From: Kathryn Welch
Sent: 31 March 2026 17:06
To: Planning Scanning
Subject: FW: Y/10/26/PL Rookery Farm

From: Kathryn Welch
Sent: 20 March 2026 14:28
To: [REDACTED]
Subject: Y/10/26/PL Rookery Farm

As discussed, it appears that the proposal has evolved beyond the original intention of simply providing 1 new dwelling. Given the extent of development to the rear, the application should be amended to include the change of use of the agricultural land behind the barn to residential use. I would also suggest that the application does not need to refer to the demolition; instead, a retrospective application for the erection of the number of new dwellings would be more appropriate.

2601_200_PL0
*** PROPOSED DRAWINGS**

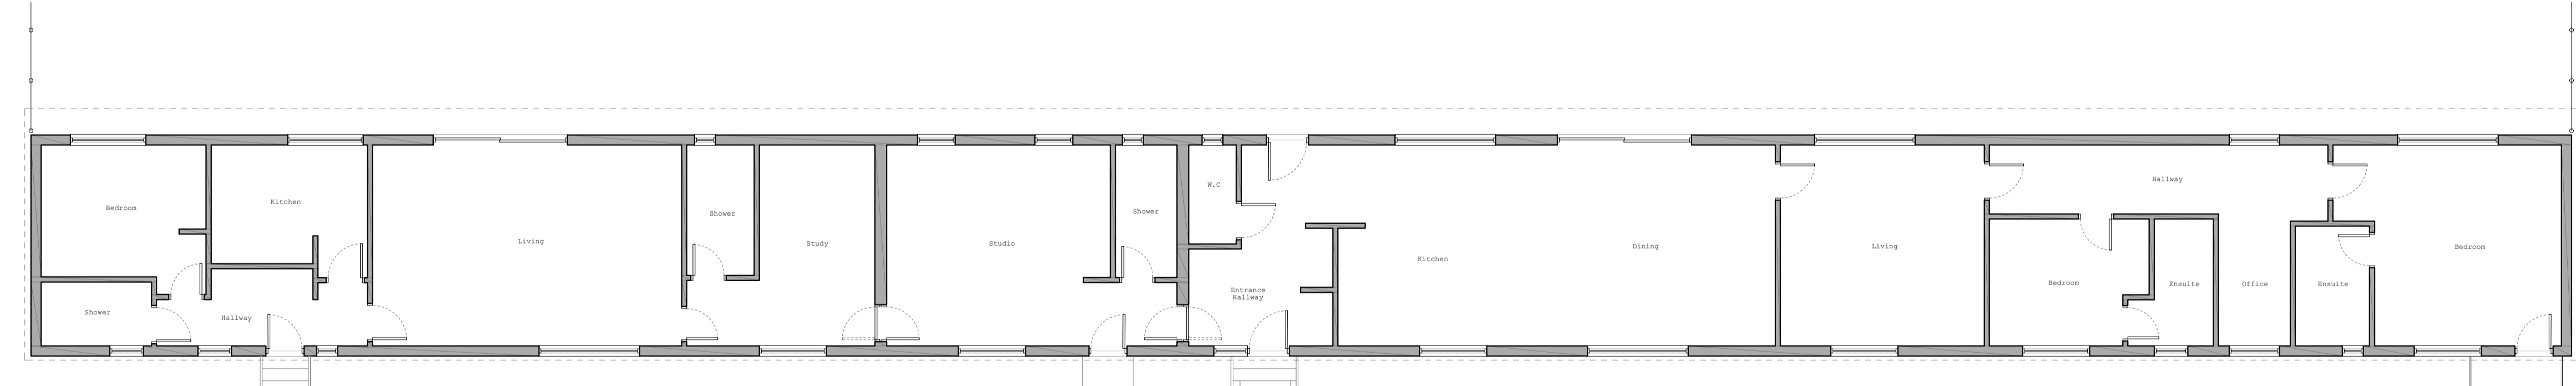
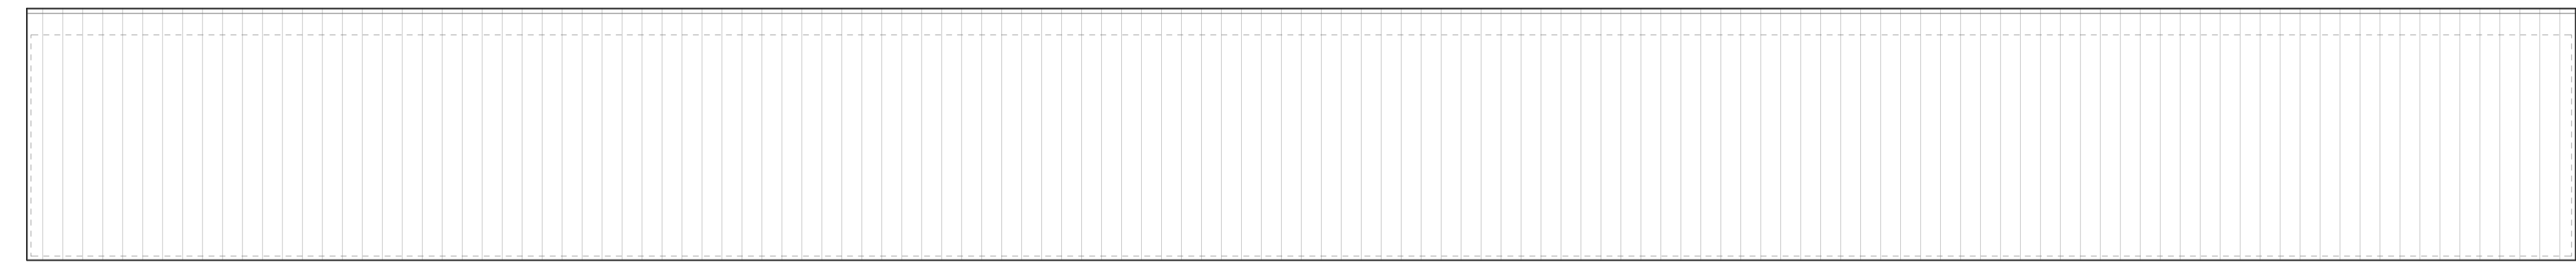
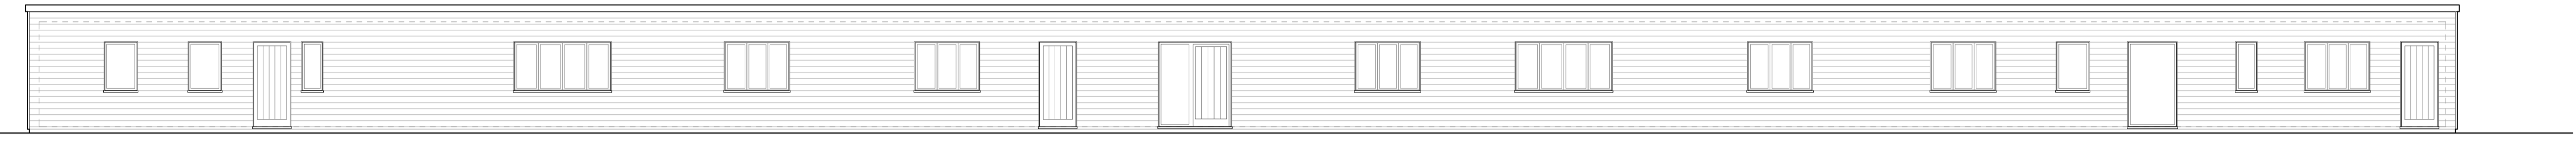
With regard to the number of dwellings on the site, I consider it evident that; despite the interconnectivity, the building has been designed to function as up to three separate dwellings. Evidence observed on site, including the number of front doors, subdivision of the land, and the number of ASHP units, has informed this view. I have also been provided with a Building Control report which confirms that the structure was designed as three separate dwellings for the purposes of fire-spread regulations.

Finally, I noted during my visit that construction of a pergola has commenced at the rear of the property. Given the scale of this structure, I would recommend including it within the submitted plans.
